INNER WEST COUNCIL – RESPONSE TO DESIGN AMENDMENT REPORT

WESTCONNEX STAGE 3 (M4-M5 LINK – ROZELLE INTERCHANGE)

SSI-7485-MOD-2 APRIL 2020

Figure 1-1 The revised design

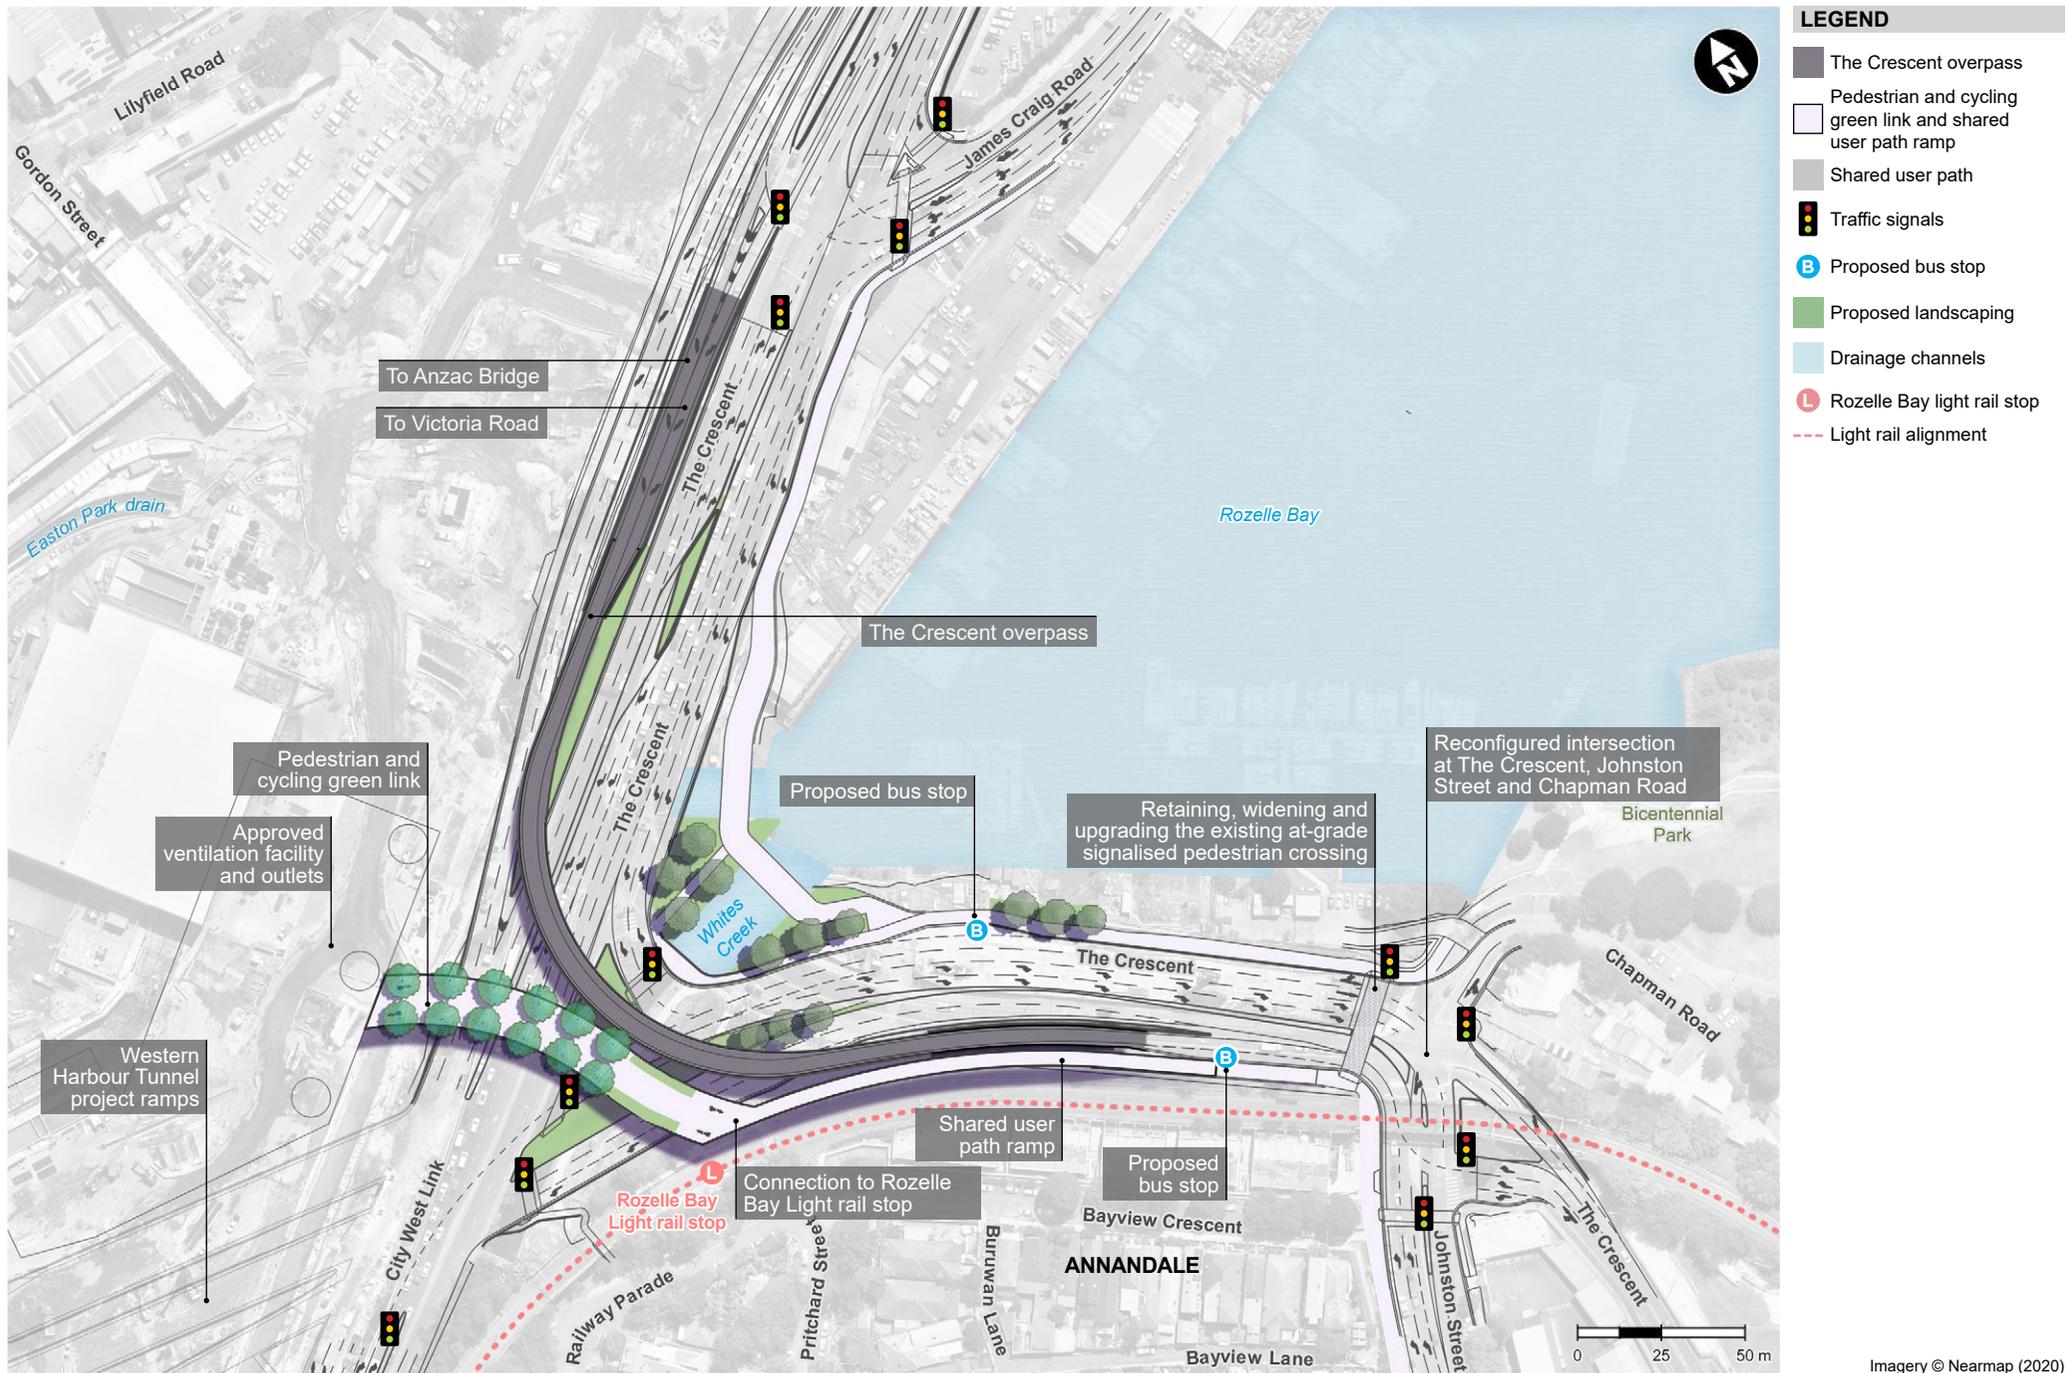
Inner West Council is pleased to see changes made to Modification 2 in response to community feedback. Reinstatement of the direct pedestrian crossing between Johnston Street and parks on foreshore is critical to support local access and Council supports the reduced height of the overpass roadway. The involvement of an independent urban design review panel has resulted in better outcomes and Inner West Council urges Transport for NSW to ensure improved urban design and local connectivity are the lens through which all road projects are viewed in this inner city area. Council would like to see the seamless links originally proposed between existing and proposed open space provided as part of the modification.

A path providing seamless walking and cycling access between the future park and the existing foreshore parks needs to be provided, consistent with the EIS.

The EIS showed a green link connecting the future park with the foreshore parks and the light rail stop with a pedestrian ramp from the light rail stop to the western side of The Crescent and the existing crossing of The Crescent at Chapman Road. The EIS states it was designed to maintain and enhance walking and cycling accessibility and connectivity with new and upgraded east–west connections and north–south connections and this needs to be maintained.

The revised design will potentially result in large groups of people including school groups, families, scooters and bicycles waiting on the corner of Johnston Street and The Crescent. Meanwhile access from Railway Parade to the foreshore at street level will require three road crossings beneath the elevated structures among freeway like roads.

A well-designed pedestrian bridge with input from the urban design review panel could provide a park-to-park connection with a continuous grade-separated path between the future parklands at Rozelle Rail Yards and the existing parks on the foreshore including the new skate park and playground. It would provide Connectivity of and access to diverse open spaces as identified by the Eastern District Plan

Figure 4-5 The Crescent/Johnston Street/Chapman Road intersection

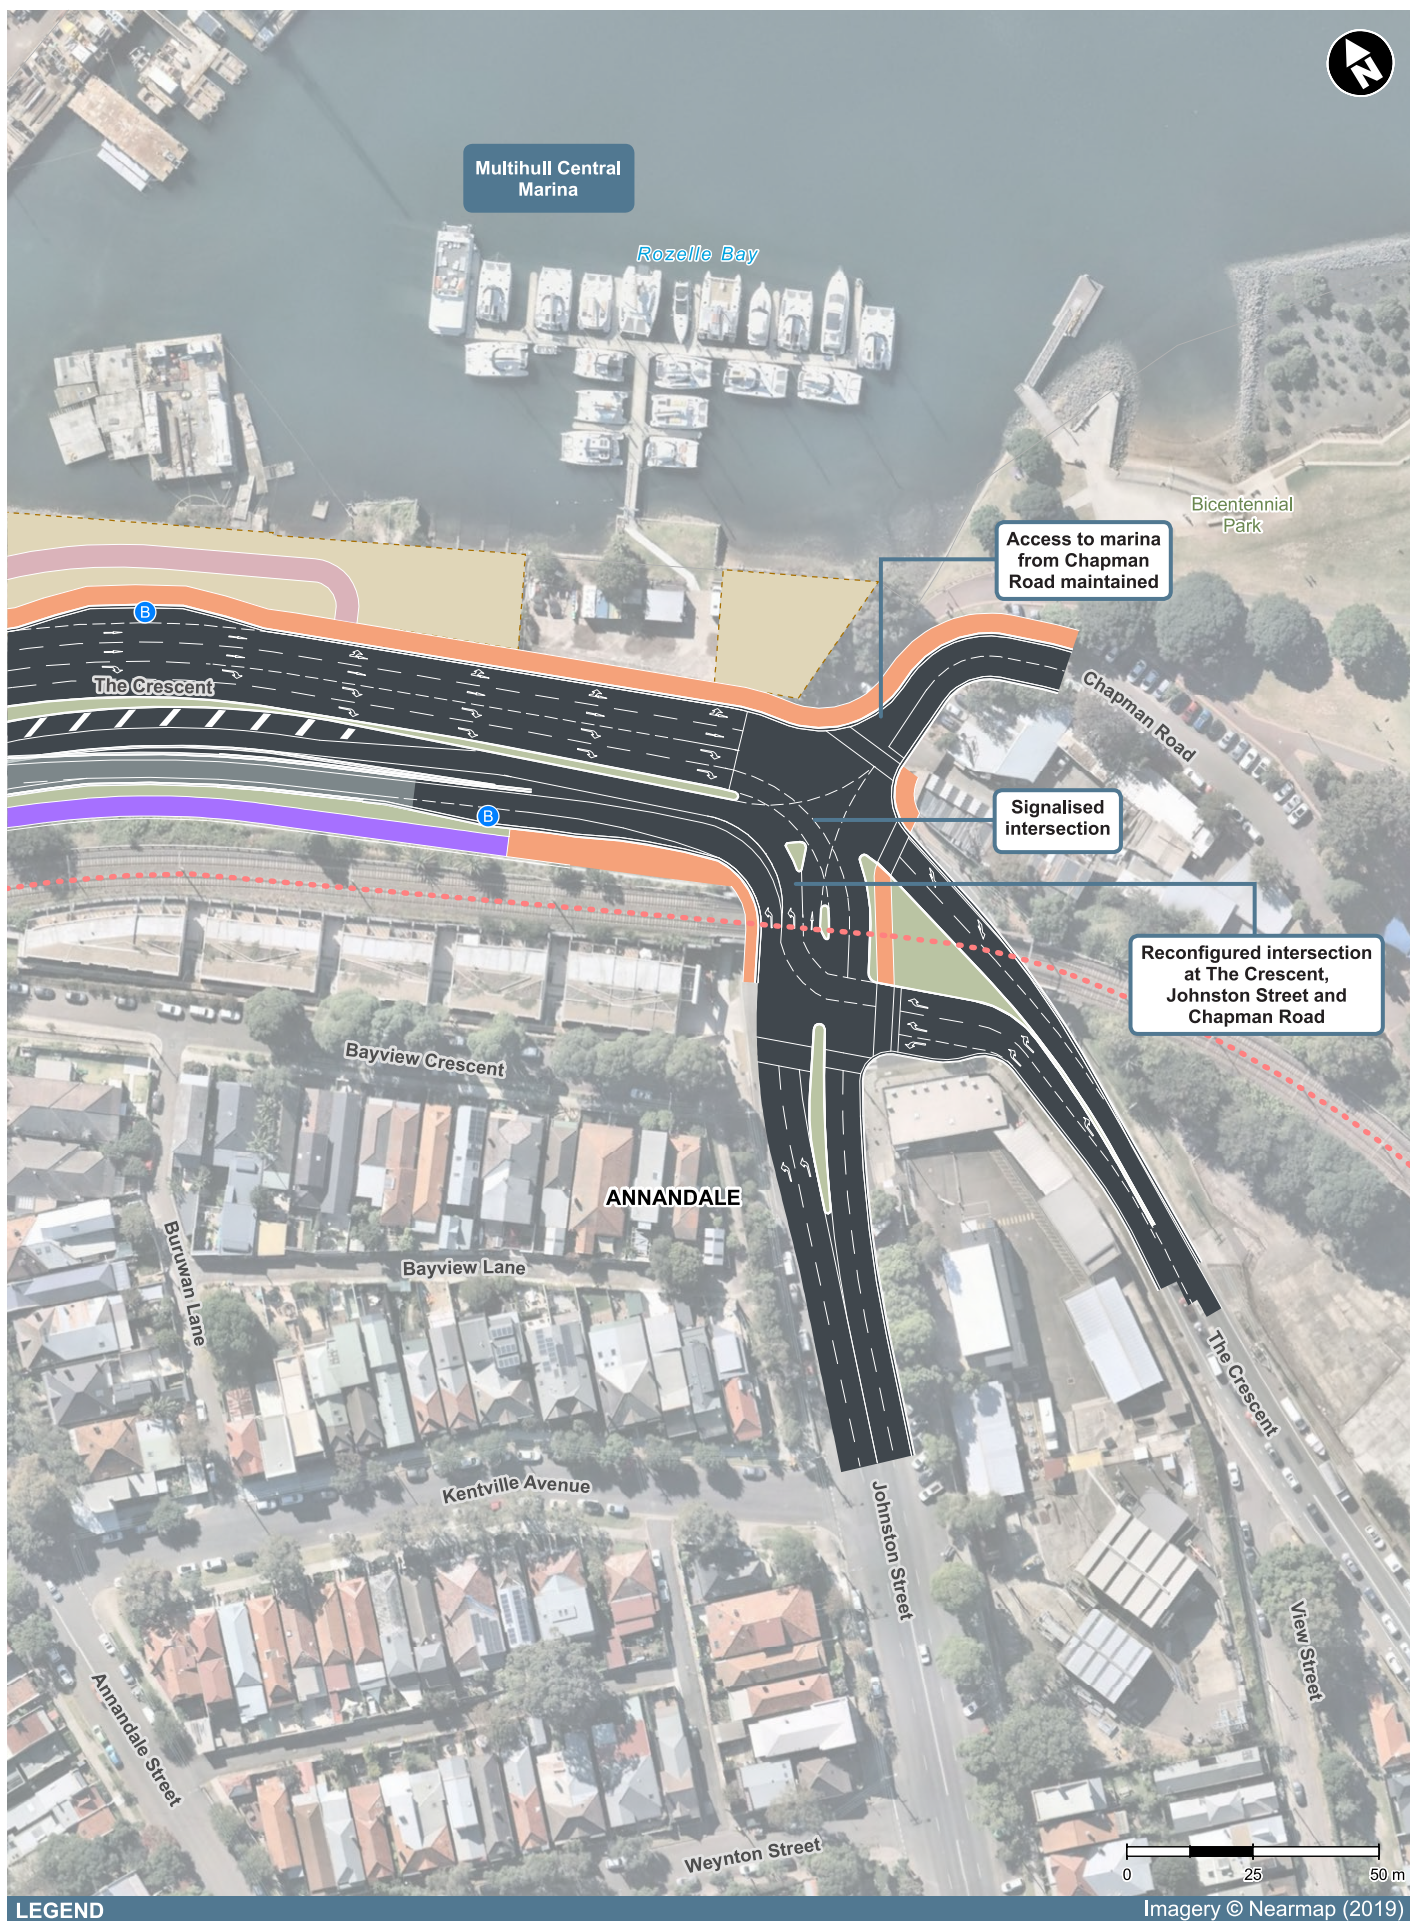
- Signage for motorists on Johnston Street and The Crescent about using the correct lane to access the overpass should not block footpath access or impose on people's homes.
- Shared path markings should be installed in accordance with City of Sydney Shared Pathways Pavement Markings Guide
- Bicycle lanterns need to be provided at the Johnston Street pedestrian crossing
- Consideration should be given to storage space catering for cyclists at the intersection of Johnston Street and The Crescent
- Consideration should be given to the provision of cycling lanes on Johnston Street between The Crescent and Piper Street Annandale.
